KIRKLEES METROPOLITAN COUNCIL INVESTMENT & REGENERATION SERVICE

DELEGATED DECISION TO DETERMINE APPLICATIONS FOR CONSENT, AGREEMENT OR APPROVAL REQUIRED BY CONDITION

Reference No:	2026/44/91278/W
Site Address:	Land off, Bankfield Drive, Holmbridge, Holmfirth, HD9 2PH
Description:	Discharge of details reserved by conditions 3 (C(E)MP) and 7 (wastes) on previous permission 2023/91212 for erection of 21 dwellings with access from Laithe Avenue
Recommending Officer:	Ellie Thornhill

Reference: 2026/91278

# Bankfield Drive, Holmbridge - 2400-02-009

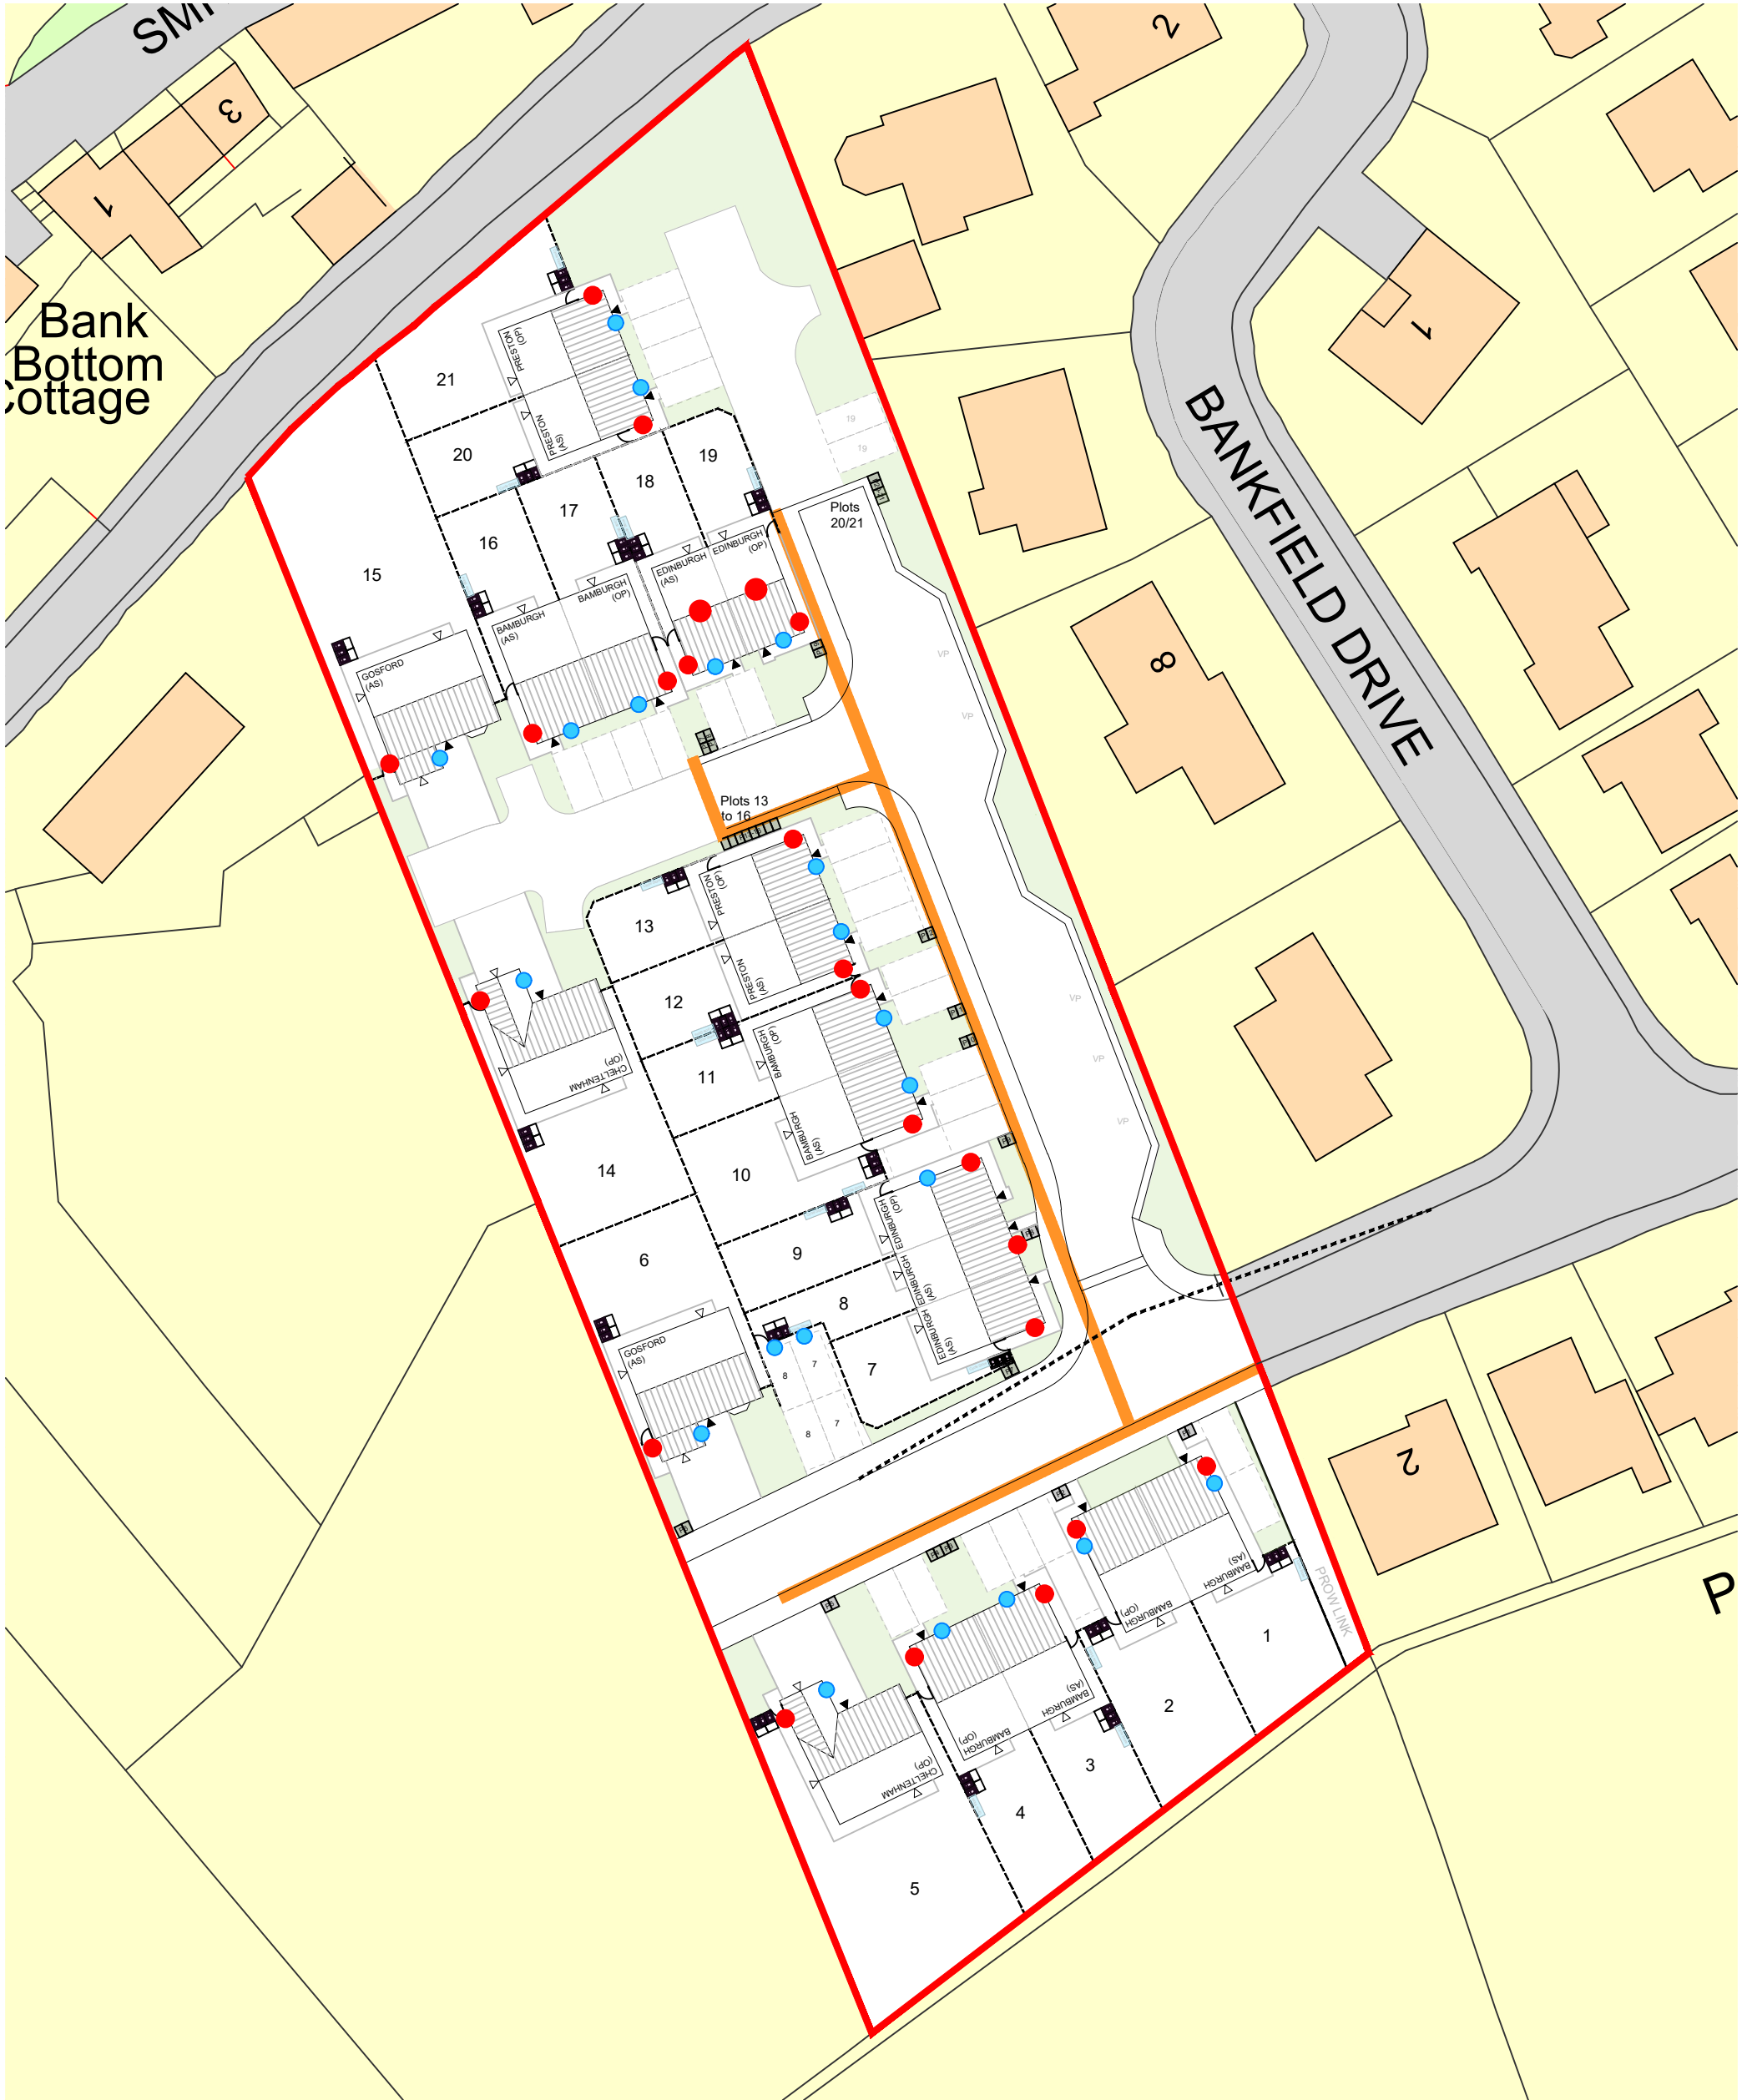
Given the information provided by the developer the WCA can agree to the Discharge of Condition 7 for the site.

Planning officers concur with the conclusions made by KC Waste Strategy and therefore the information submitted pursuant to condition 7 is considered acceptable, and is recommended to be approved.

Appendix 1 – CEMP Plan

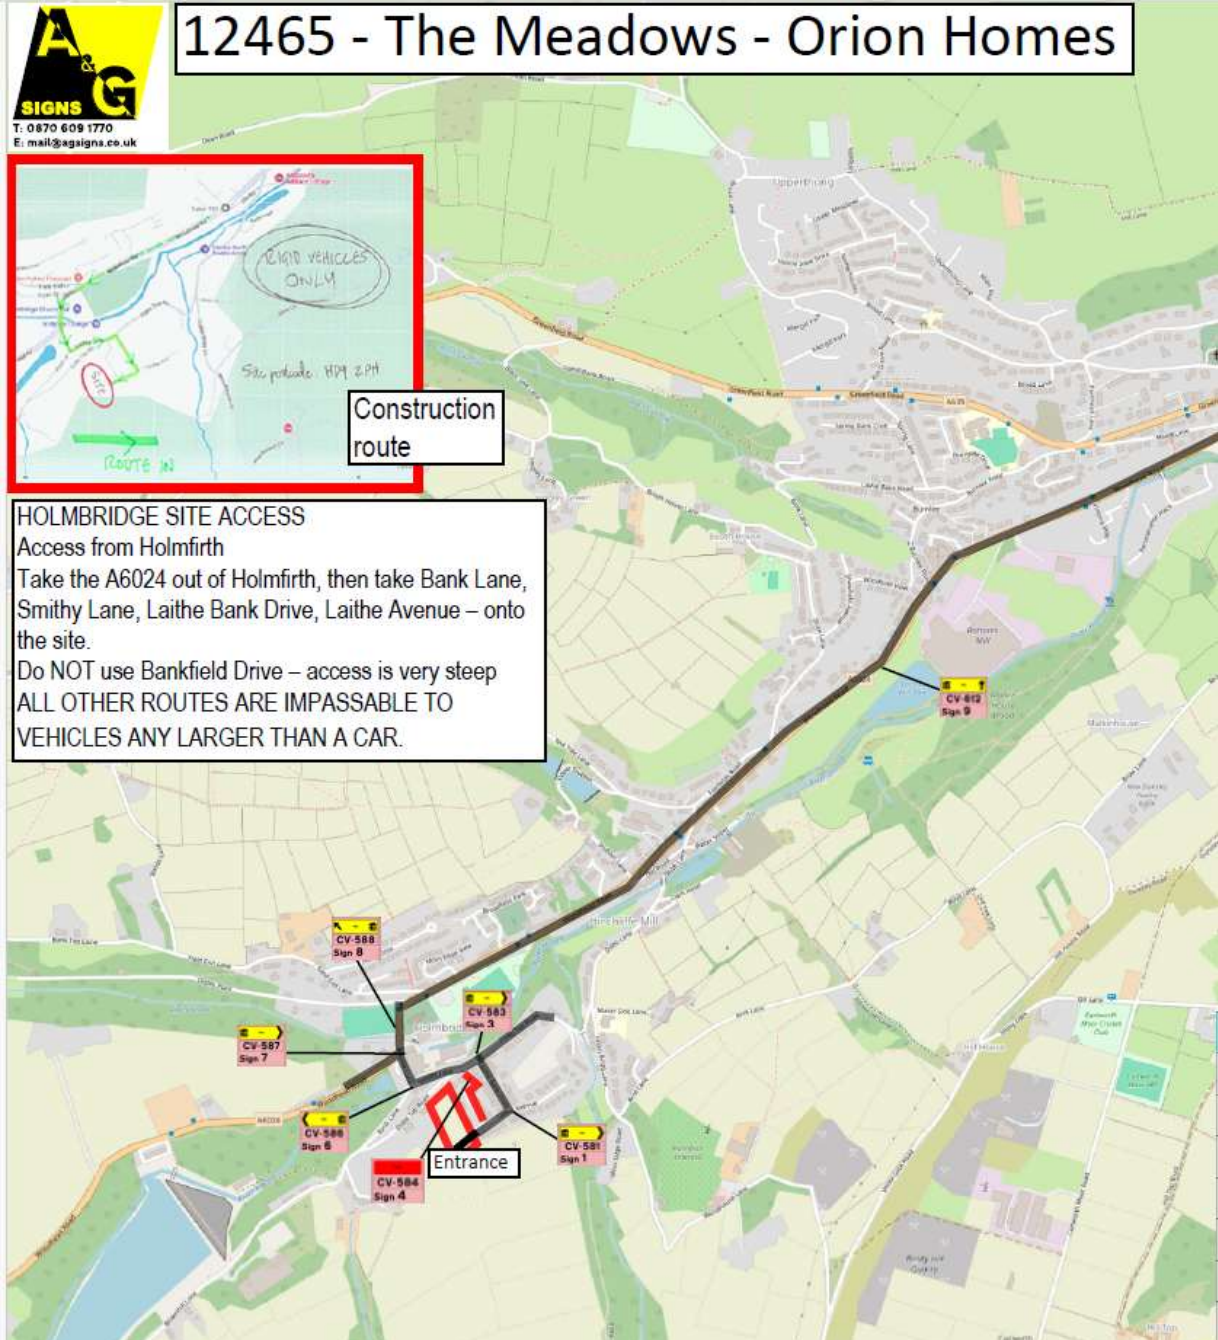
This is identified within appendix 1, which shows a total of 27 on-site parking spaces for construction workers. The parking spaces would all have a sign in the ground to make workers aware.

The document identifies that the orange spaces (a total of 19) would be relocated as the site progresses.

Parking bays shown in orange on the plan will be demarcated using pin kerbs and the parking bays shown in pink will be marked out using spray paint.

These facilities are considered commensurate to the scale of the proposal and expected level of workers on-site, overcoming previous concerns raised.

A loading/unloading area of plant and material is demonstrated within appendix 1. This would then be stored in the site compound.
